CITY OF ALBUQUERQUE
MUNICIPAL DEVELOPMENT DEPARTMENT
ENGINEERING DIVISION

CONFERENCE RECAP

SUBJECT: Juan Tabo - PEP BOYS
1308 Juan Tabo Blvd. Tract 2-2B Dale Ballman
Adm'n.

REF: PEP BOYS SITE TRACT Z-2-B, DALE J. BELLAMAH'S UNIT 4 EASTRIDGE
(J22-D39)

PEP BOYS SITE AT JUAN TABO BLVD. GRADING PLAN Project No. _____ Job No. 42452 Sheet 2 of 2 Drawn By: JTR Date: 10/04 Checked By: JT Scale: 1" = 30' Date: 12/24/04 Revised Site Plan	
---	--

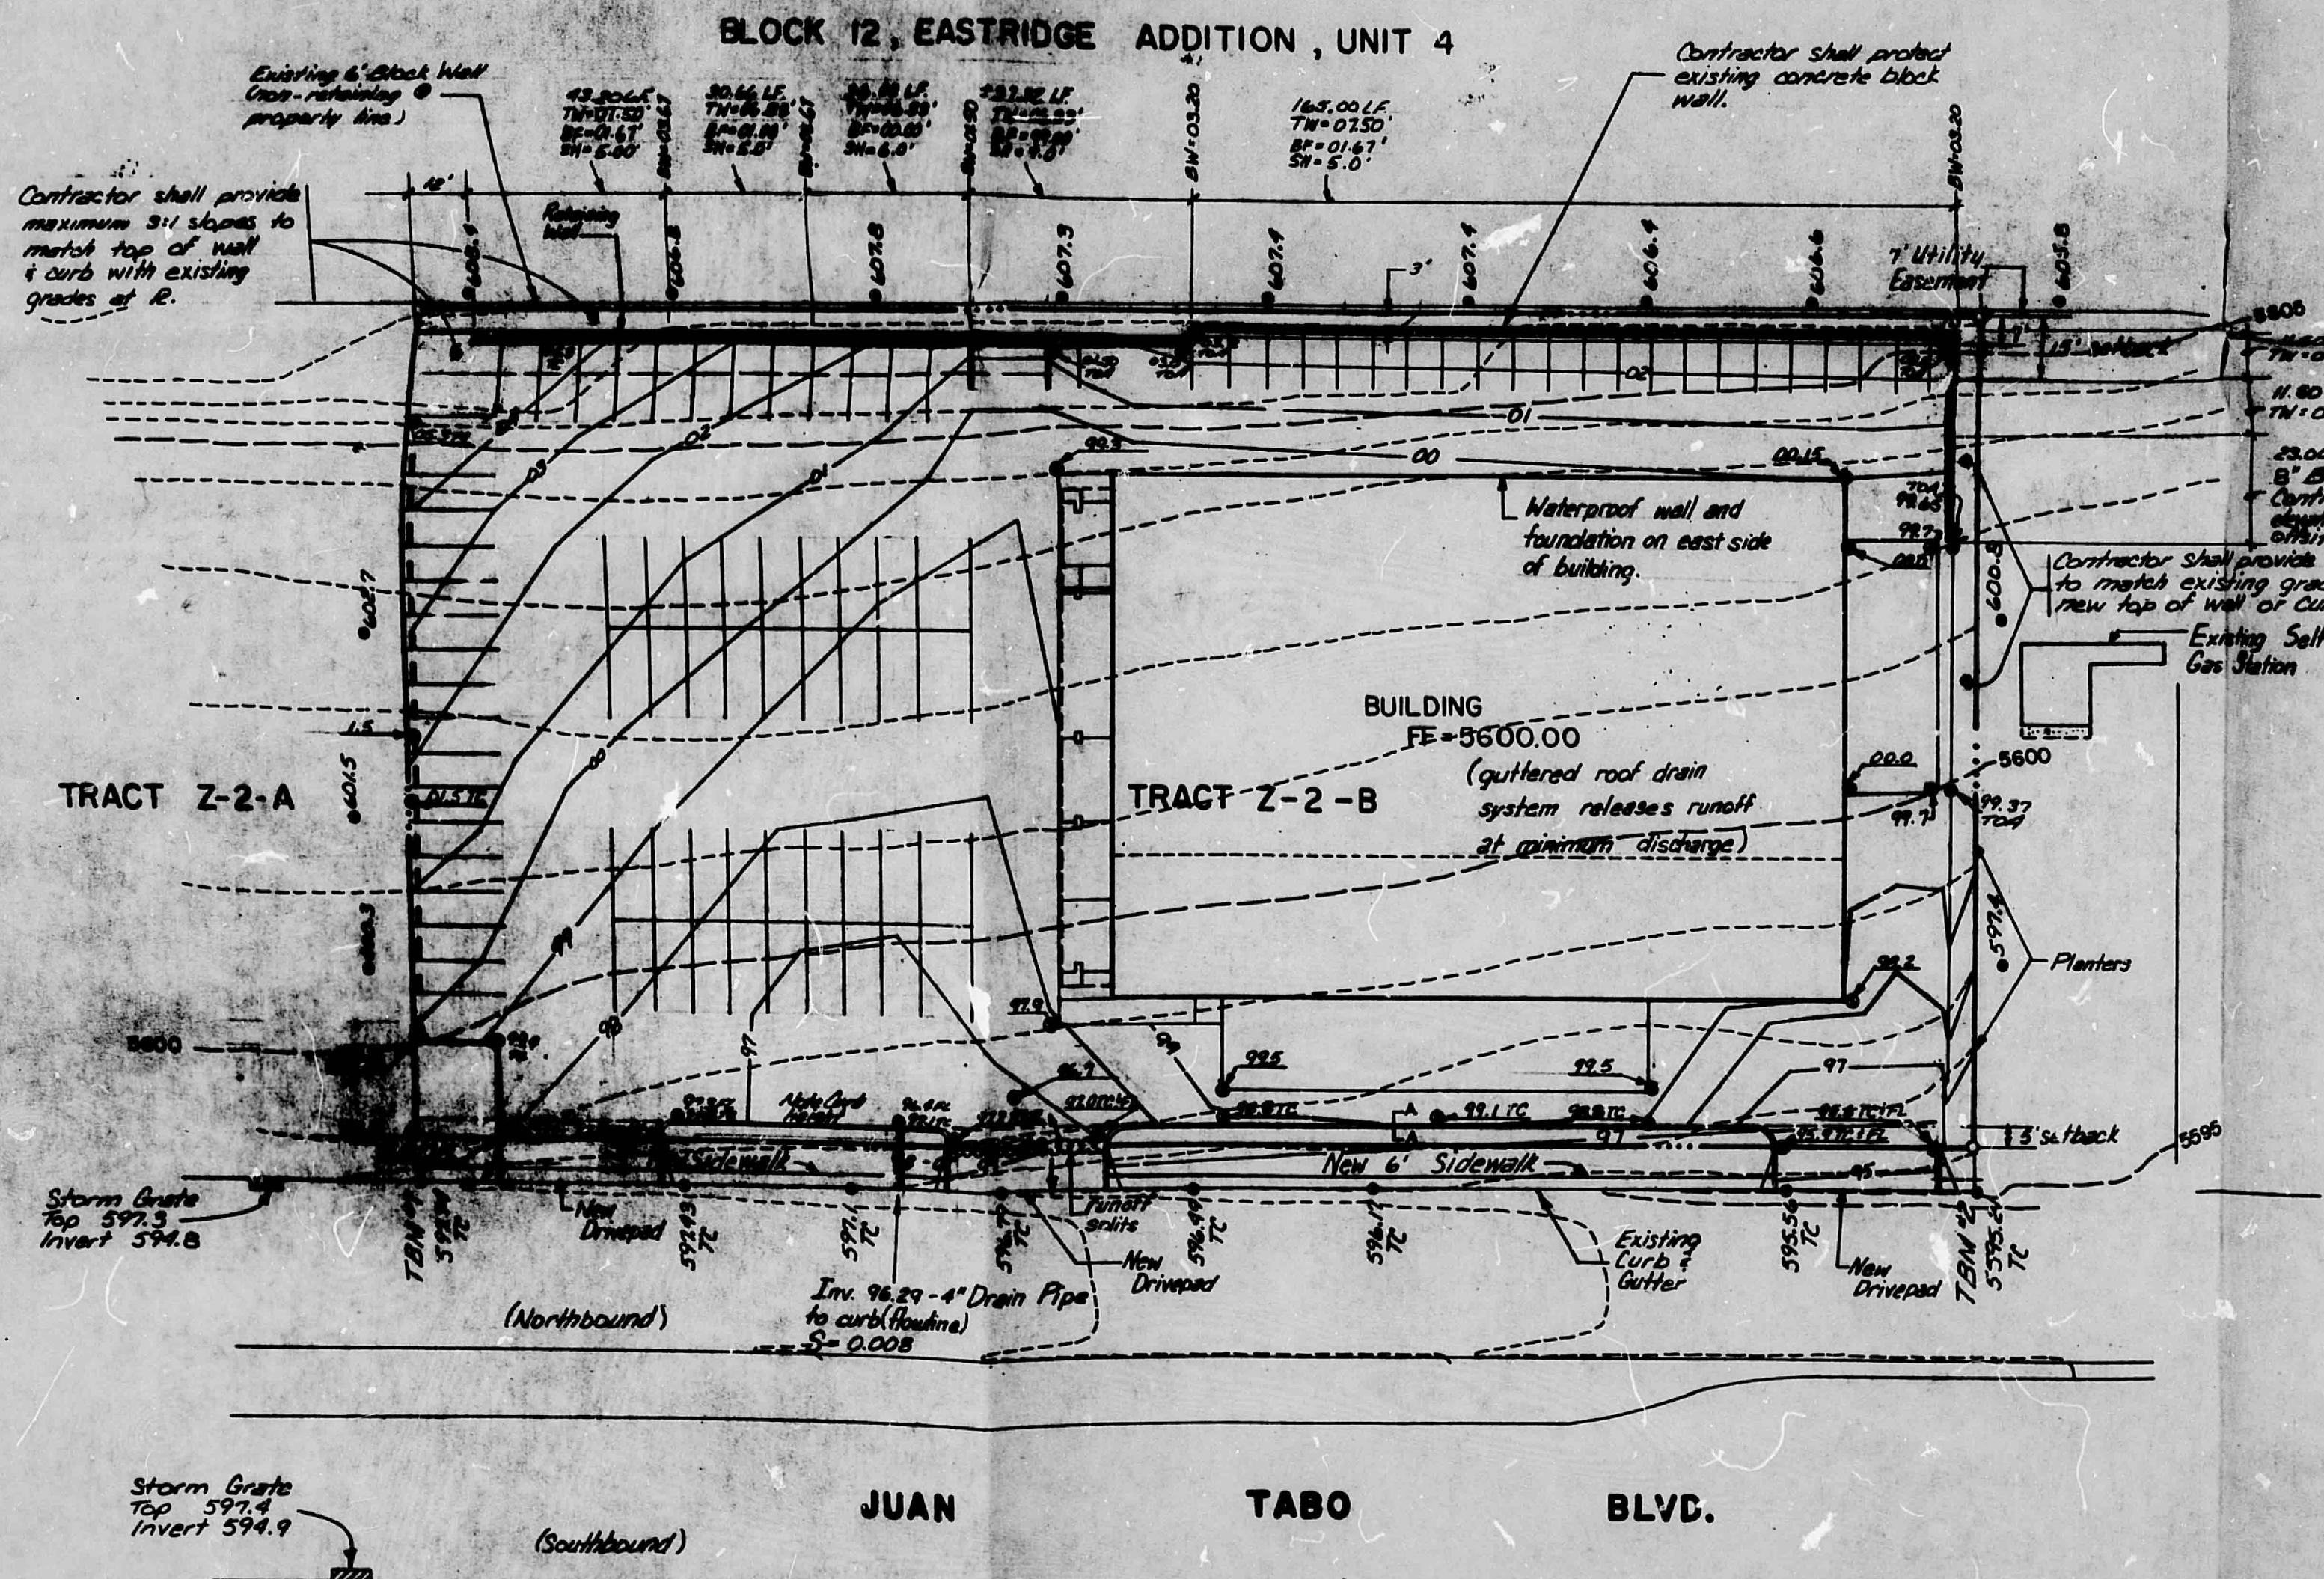
1. Information sheet with resubmittal designation.
2. Professional engineer's stamp with revised date.
3. Details of pond, water blocks, retaining wall, and all other significant structures.
4. Proposed minimum discharge roof gutter drain system will need to be certified by the engineer.
5. Direction and location of gutter system will need to be shown on the plan.
6. "Construction Within City Right-of-Way" document must be submitted to City Design Section for review.

1. **Information Sheet:** A new Information Sheet is submitted.
2. **Engineer's Stamp:** The stamp has a new date.
3. **Details:** A copy of the grading plan is attached which shows the necessary details.
4. **Roof Drainage Certification:** This Certification will be provided.
5. **Gutter System:** The locations and directions of the gutter system are shown on the revised plan.
6. **Construction Within City R-O-W:** A design for this construction has been approved by the City Design Section. A copy for your files is enclosed.

These responses address the items required for final approval. In addition to these responses, a revised site and grading plan for the site is provided so that you may insure its conformance with the drainage concepts you have initially approved. The site revisions have occurred in response to zoning comments during the City plan check process and cause only minor grading changes. The major revisions include a planting area along the east and south boundaries and some curb changes in the area of the north entrance. Drainage patterns and concepts have not been altered significantly. Ponding has been lost in the site changes but the majority of the ponding, 700 cf, remains.
